Application No: WA/18/26/PL
Site Address: Land off Arundel Road Fontwell
Description of works: Erection of 64 residential dwellings with access off Arundel Road, together with associated parking, open space, play space, landscaping, drainage and infrastructure. This application is a Departure from the Development Plan, affects a Public Right of Way, may affect the setting of listed buildings and is in CIL Zone 3 and is CIL Liable as new dwellings.

Thank you for your internet representation made on 30th March 2026 which has been recorded as an objection with the comments as follows:

Dwg. 33186-D-01 Rev. P1 land North of Arundel Road, Fontwell, Proposed Access

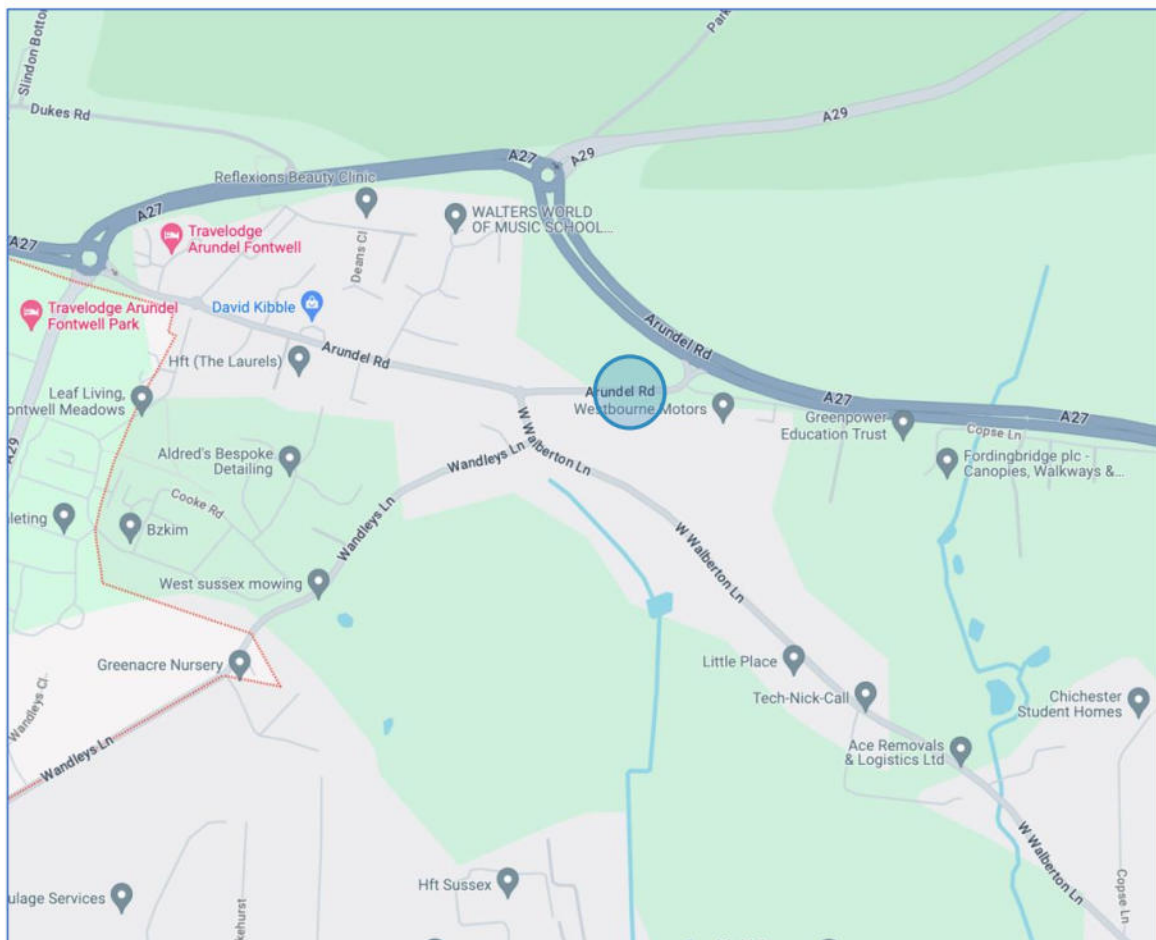
The proposal relies on a single access onto Arundel Road, directly opposite my residential driveway. This creates a clear and unavoidable vehicle conflict point for all traffic entering and exiting 64 dwellings.

Crucially, while the submitted plans show my house, they fail to show my driveway at all. This is a significant omission.

- The plans are inaccurate
- The Transport Assessment is based on incomplete information
- The Highway Authority cannot have properly assessed safety at this junction

This issue was raised in the previous application and was not addressed. It remains unresolved.
